From: Nicola Spencer
Sent: 09 June 2026 15:40
To: [REDACTED]
Subject: RE: Request for further information EP/56/26/L

Vista Point BN16 2TE
Your Reference: **EP/56/26/L** and **EP/55/26/HH**

We have received letters noting that the applications for planning and listed building consent are invalid. I would contest that these letters may have been issued in error, at least in part. Please see points below. Your queries in italics, my responses in blue.

REVISION	DATE
A	03/05/26
MINOR AMENDMENTS	02/06/26
PROJECT ADDRESS	
VISTA POINT, 21 TAMARISK WAY	
EAST PRESTON, LITTLEHAMPTON BN16 2TE	
DRAWING	
PROPOSED PLAN AND ELEVATIONS	
SCALE	
1:100 @ A1	
DRAWING No.	
2105 3PA01

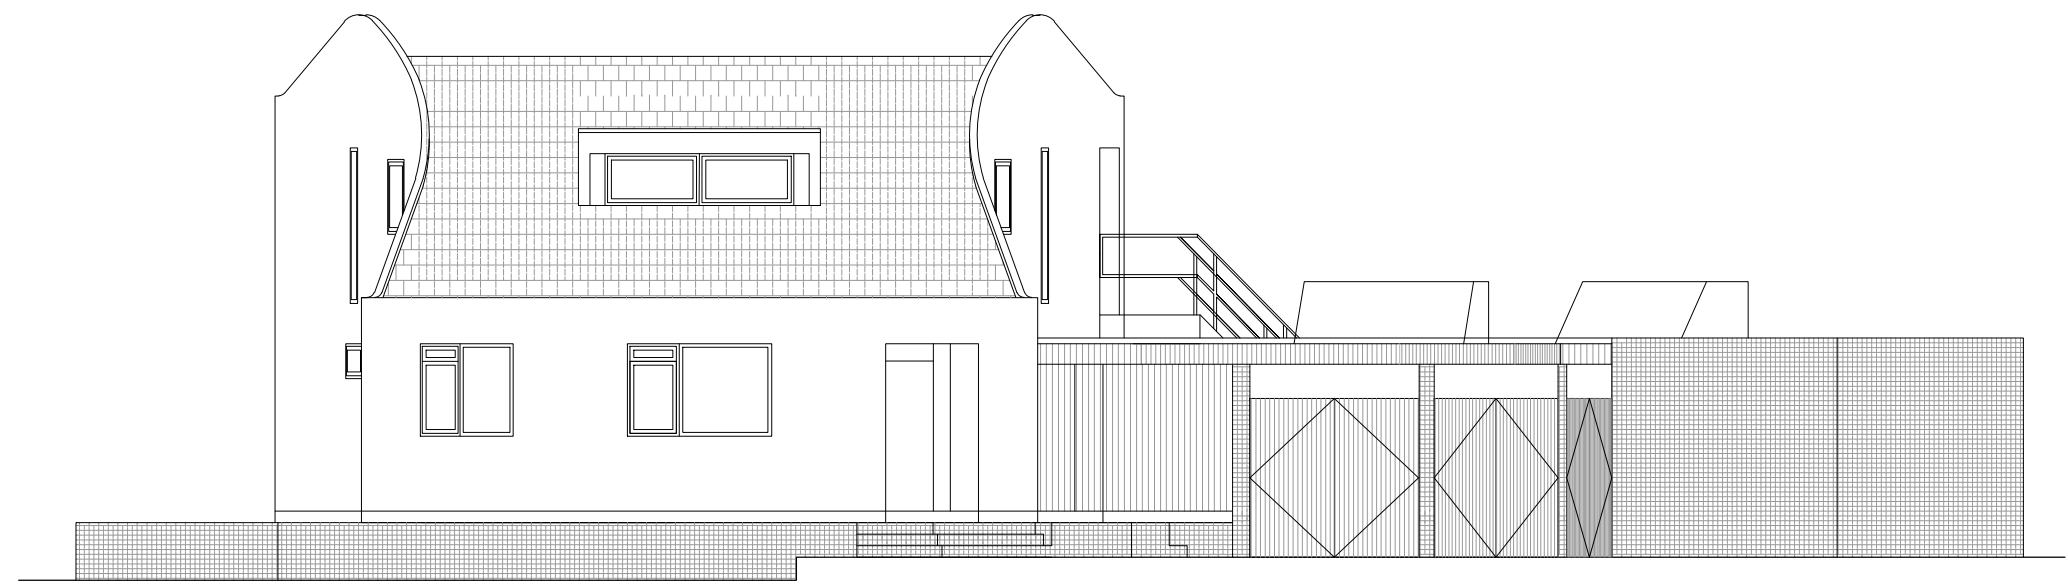
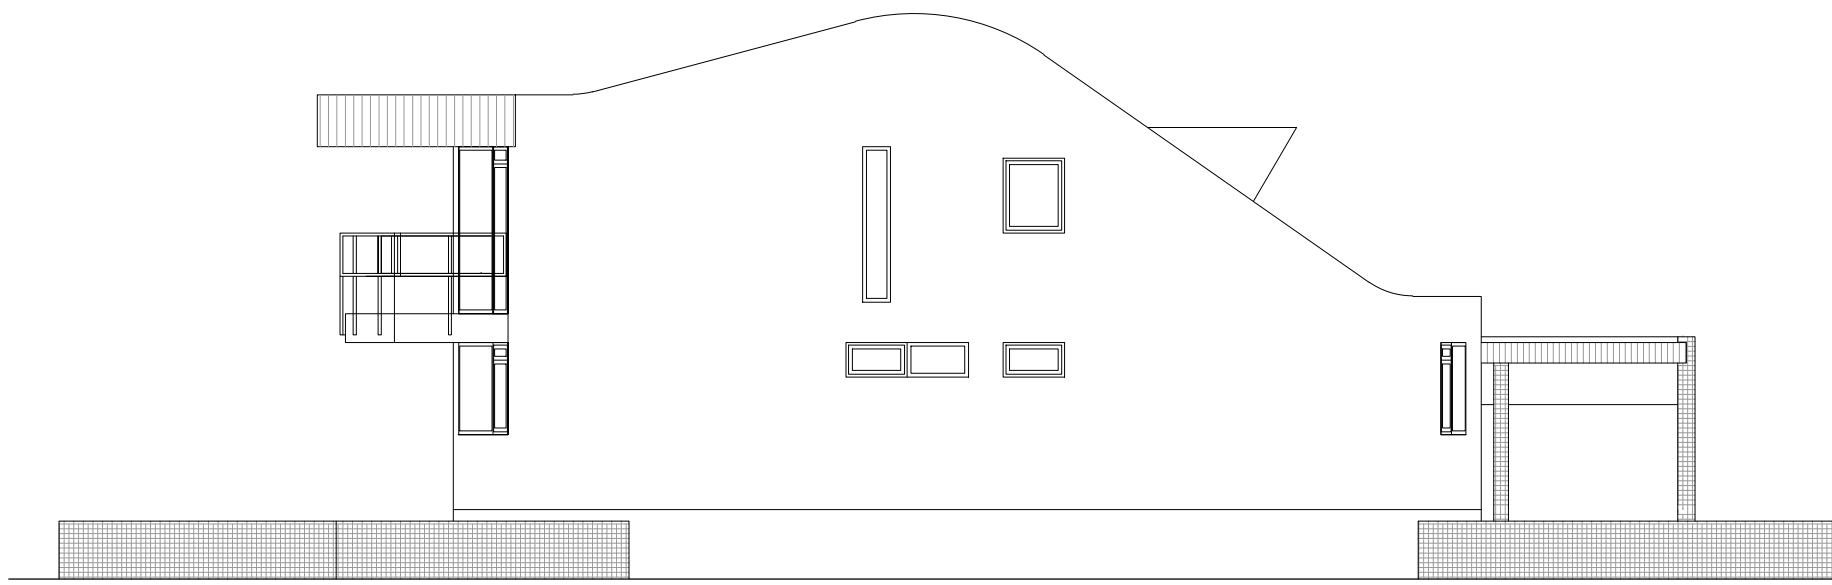
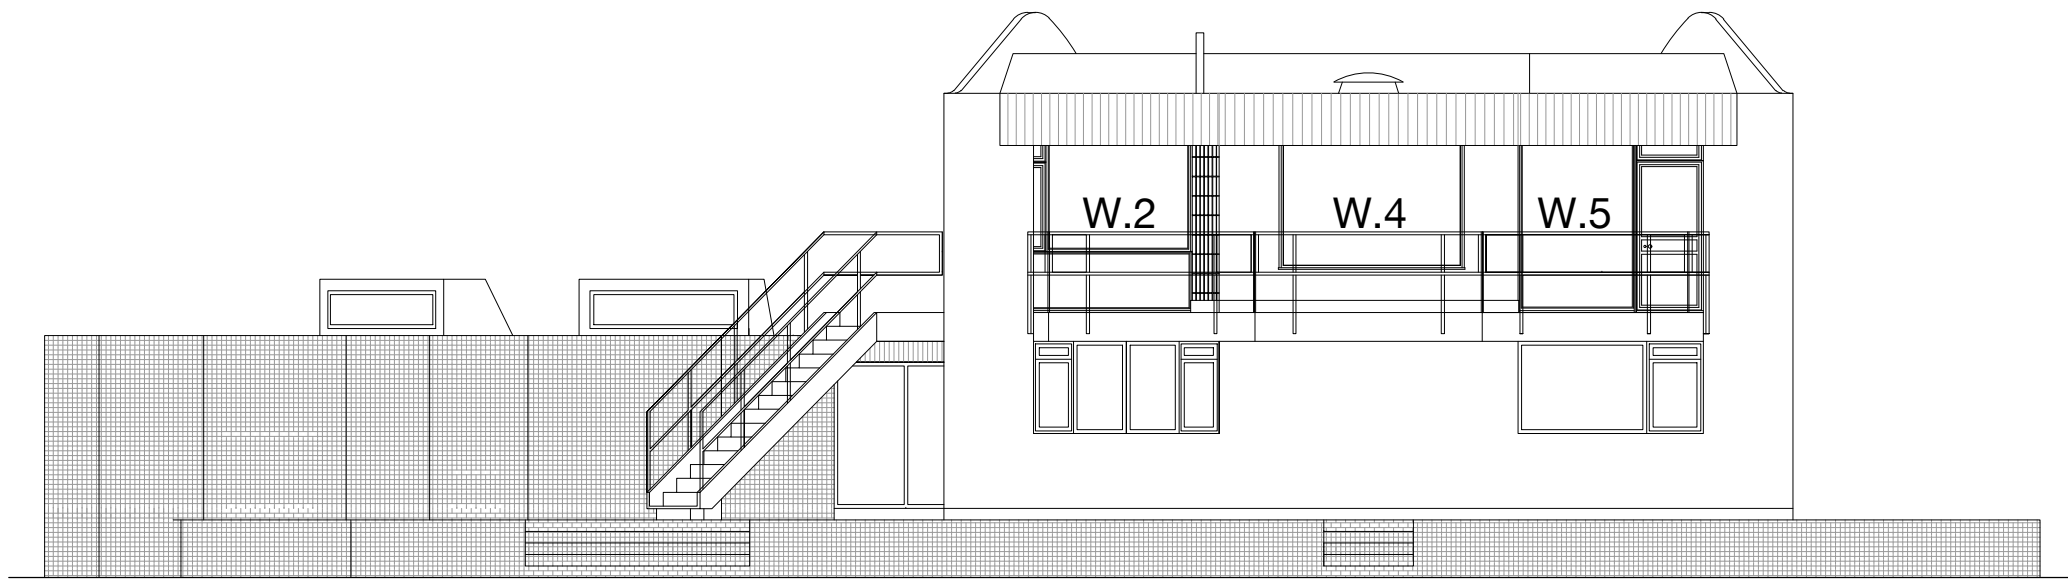
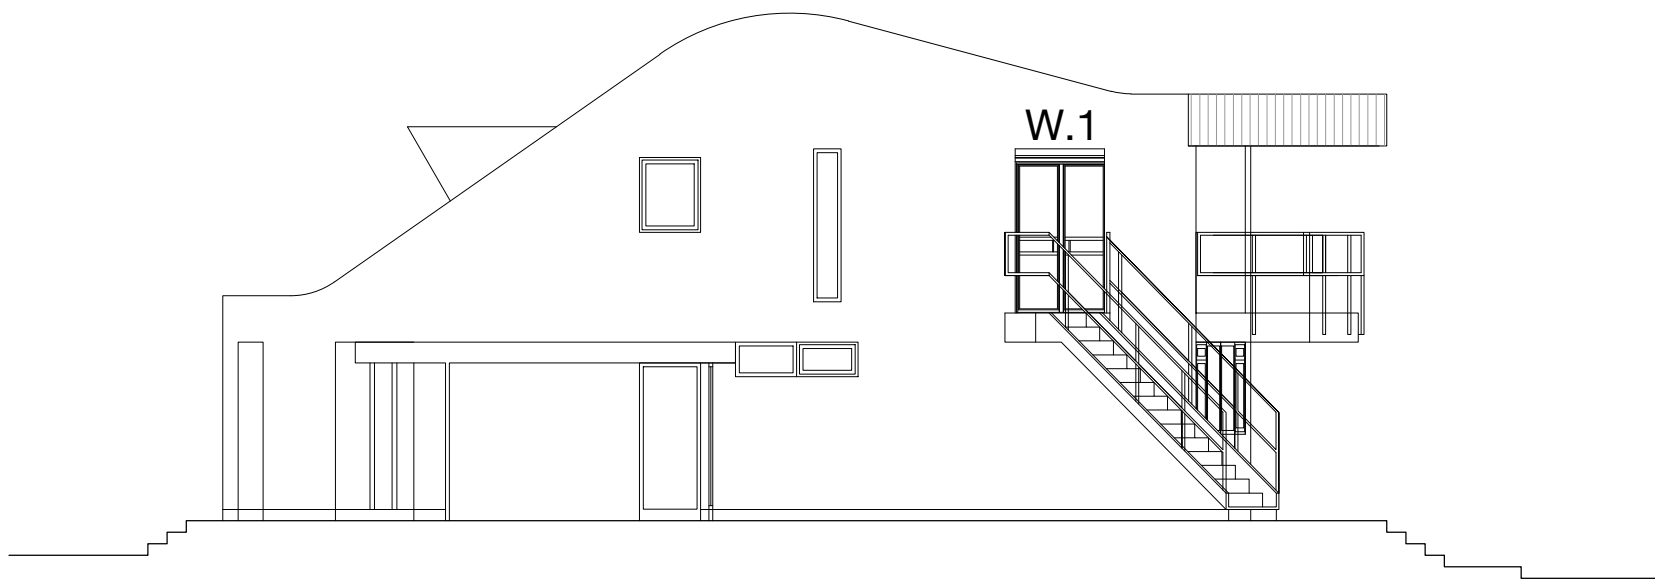
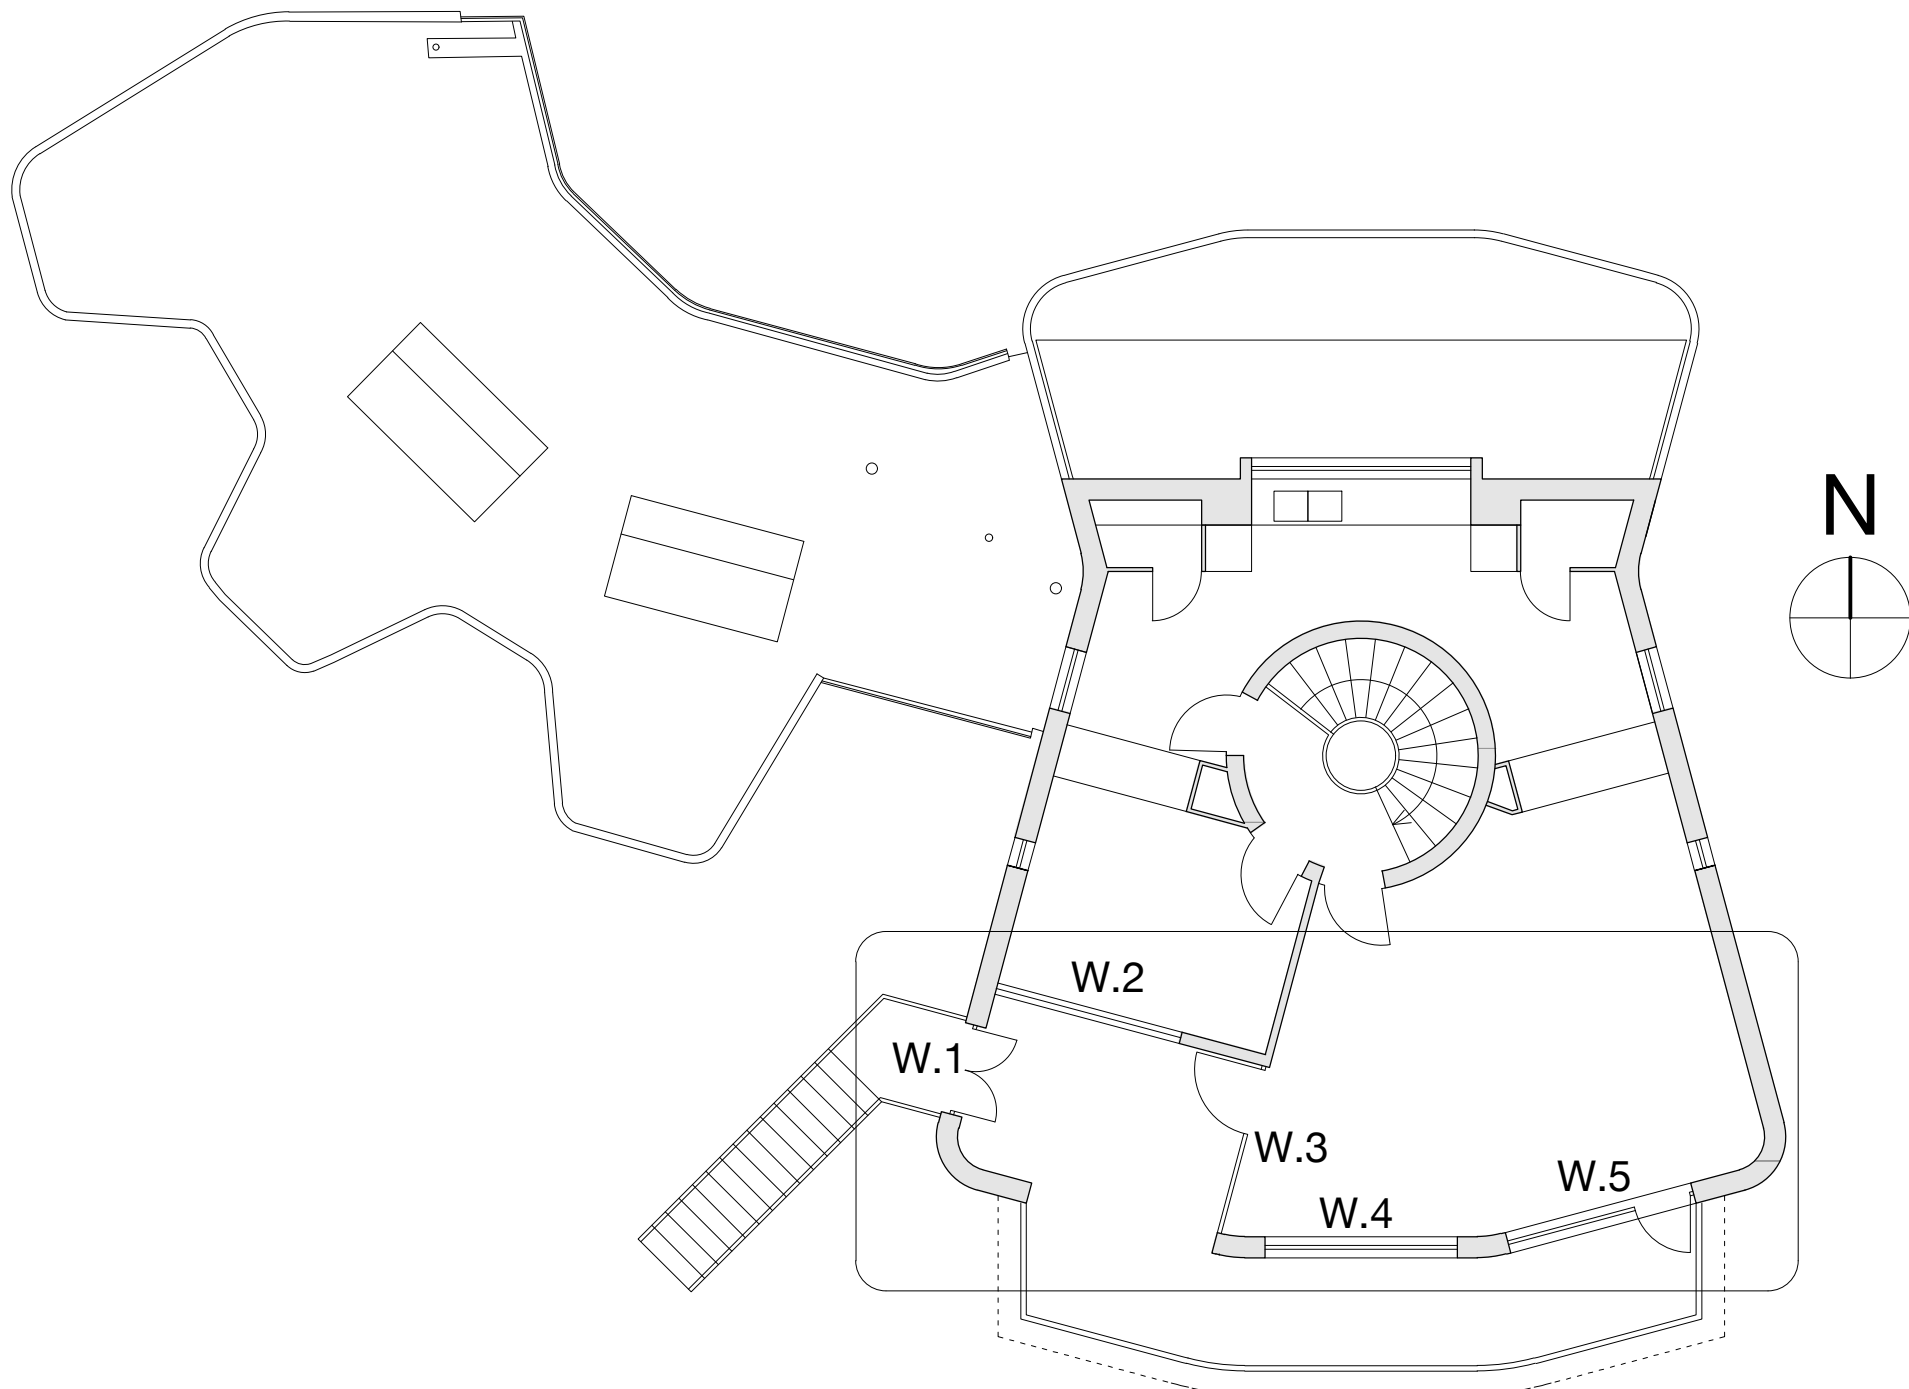
The scale bars on the proposed and existing elevation plans do not scale at 1:100. Existing and proposed elevations should either be 1:50 or 1:100."

I have checked myself and the drawings do scale at 1:100 @A1 as noted.
